## MMC Office Building Final Traffic Comments

Hi Nell – The following is a status update on prior comments and represent Final Traffic Comments. I have separated the comments that are associated with issuance of a Traffic Movement Permit.

CONGRESS STREET NEW CLINICAL TOWER
 Additions and Renovations [PEDESTRIAN ROUTING GIMAN & A STREET]

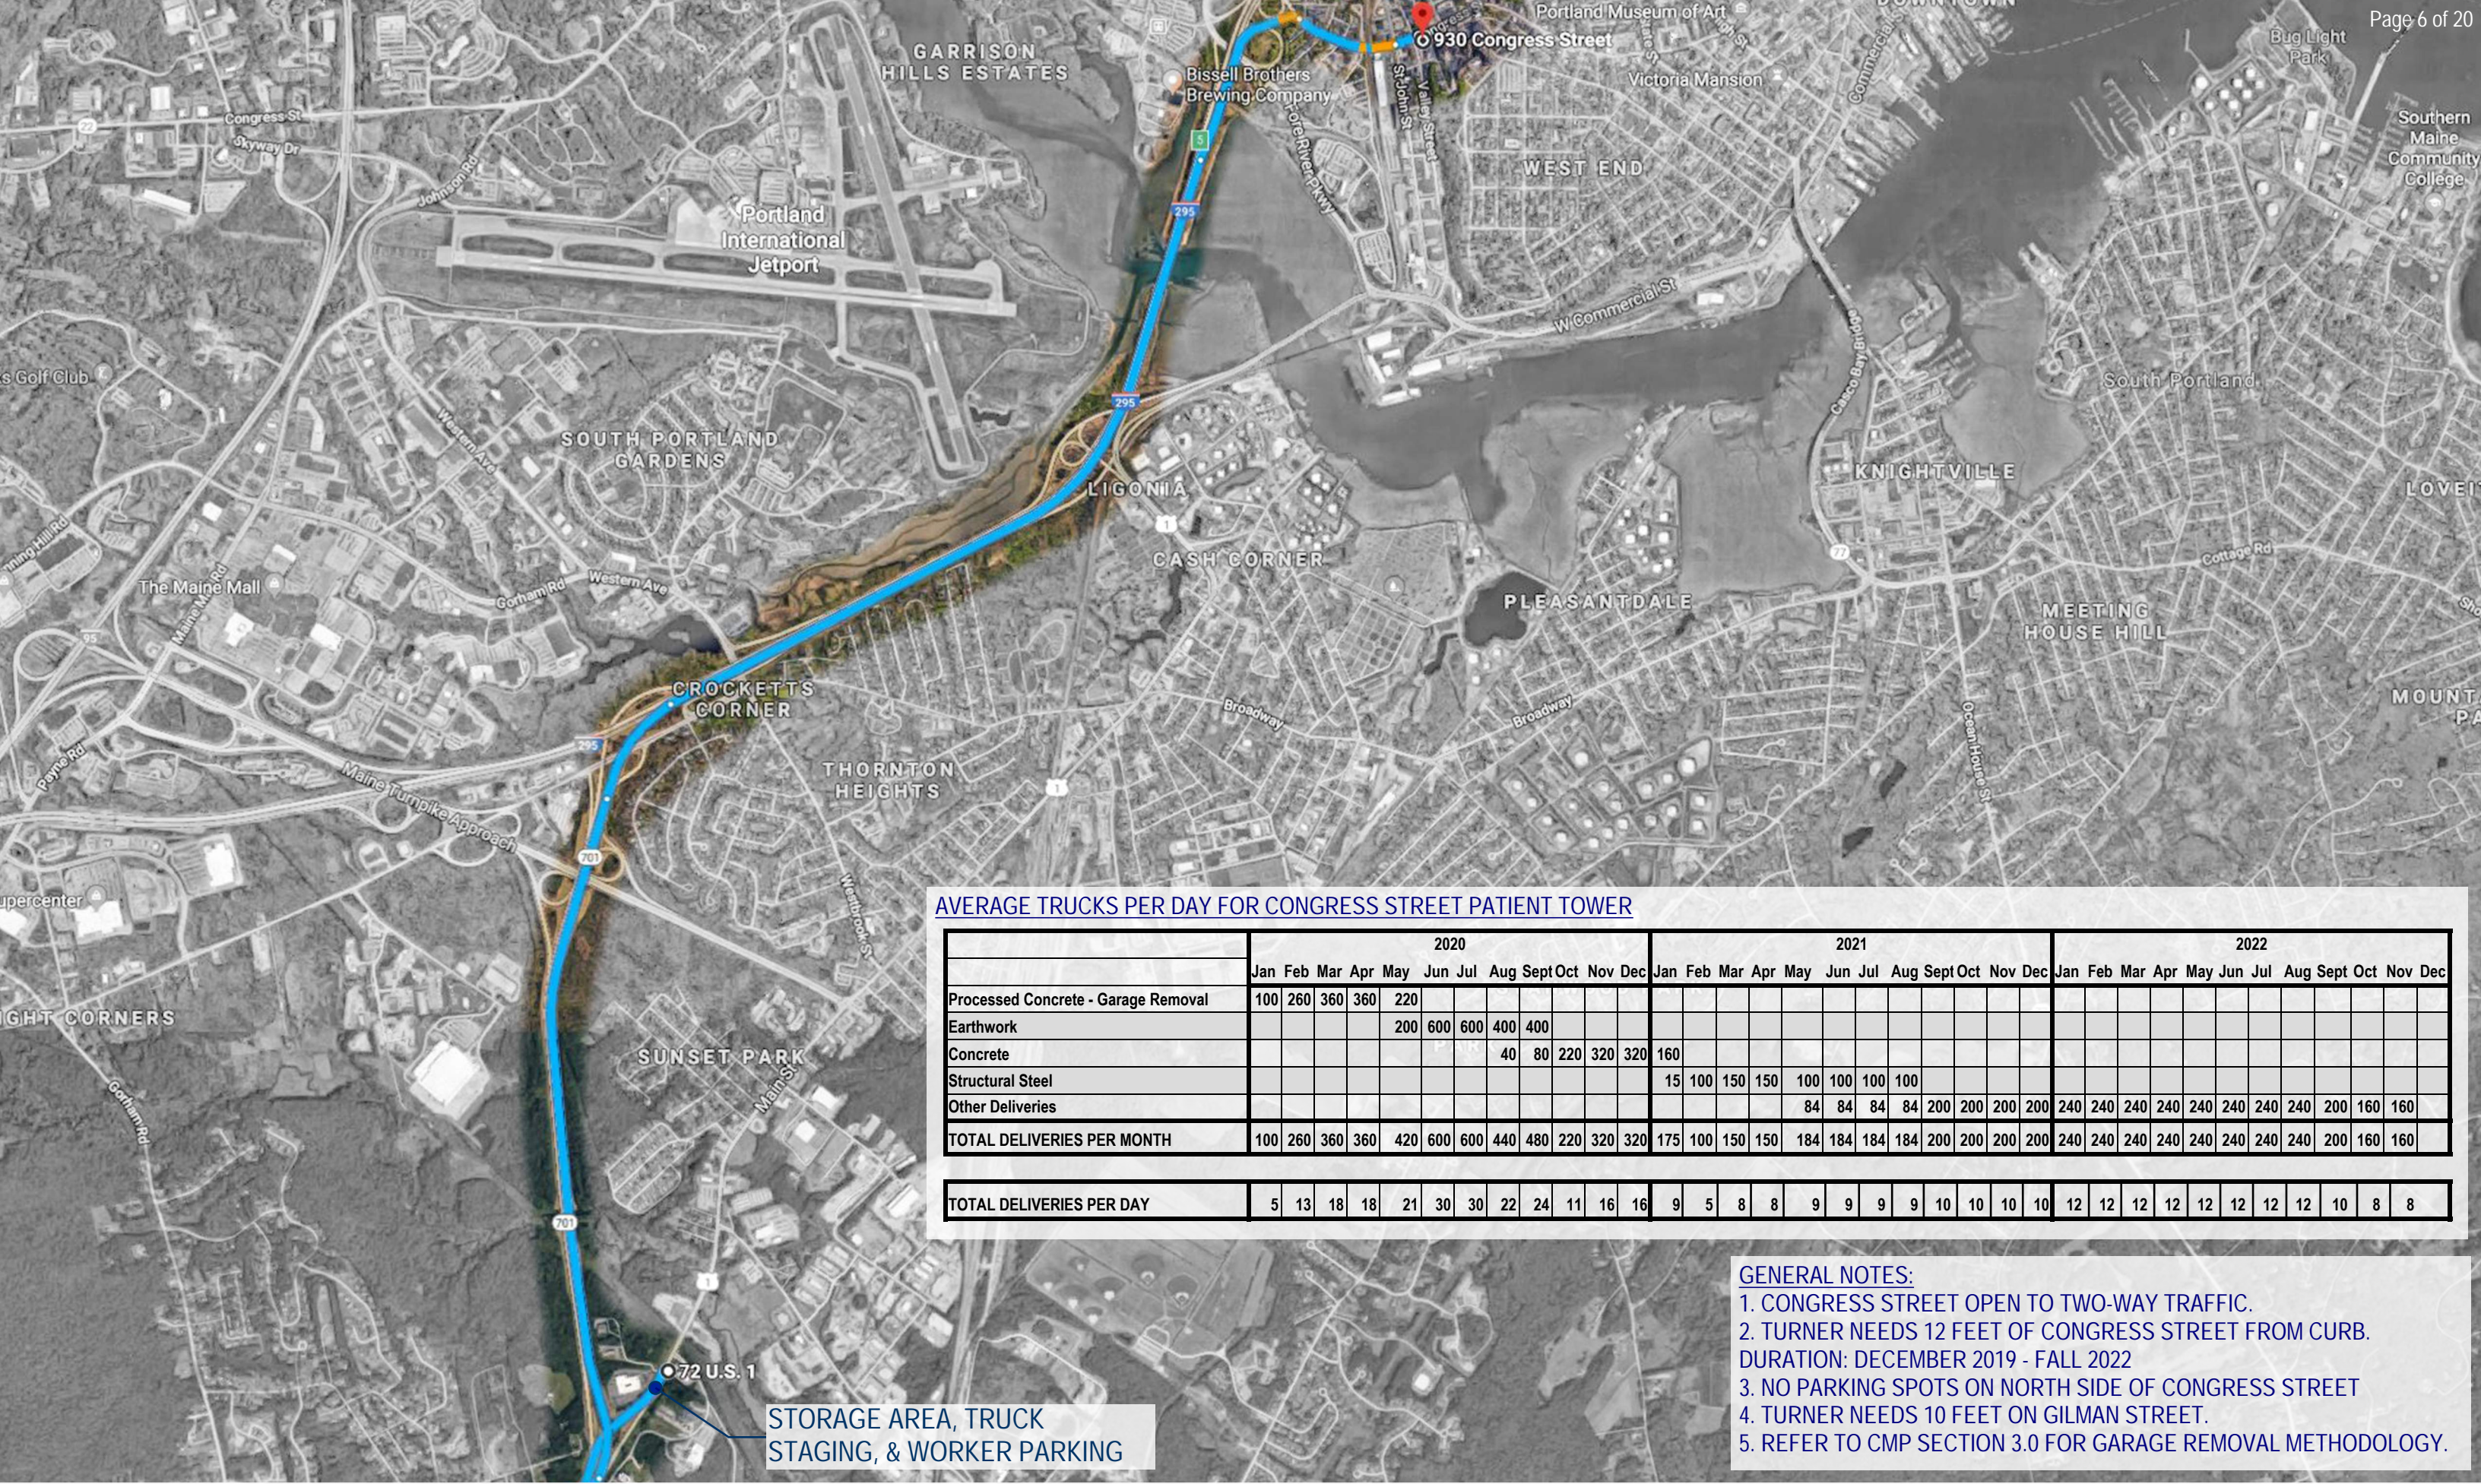
- **I have reviewed the Construction Management Plan and generally find it to be acceptable. Some specific comments:**
  - **It is recommended that further discussion on the duration of the Congress Street sidewalk closures be included.**
  - **Supplemental pedestrian safety devices will be required during the sidewalk closure time period (to safely cross pedestrians for the sidewalk detour).**
  - **All sidewalk detours shall be ADA compliant.**
  - **Changes to the lane configuration on Congress Street west of Gilman Street is likely and may need to be included in the plan.**
  - **A significant amount of construction activity will be required for utility and street construction work and specific plans shall be development for review and approval.**
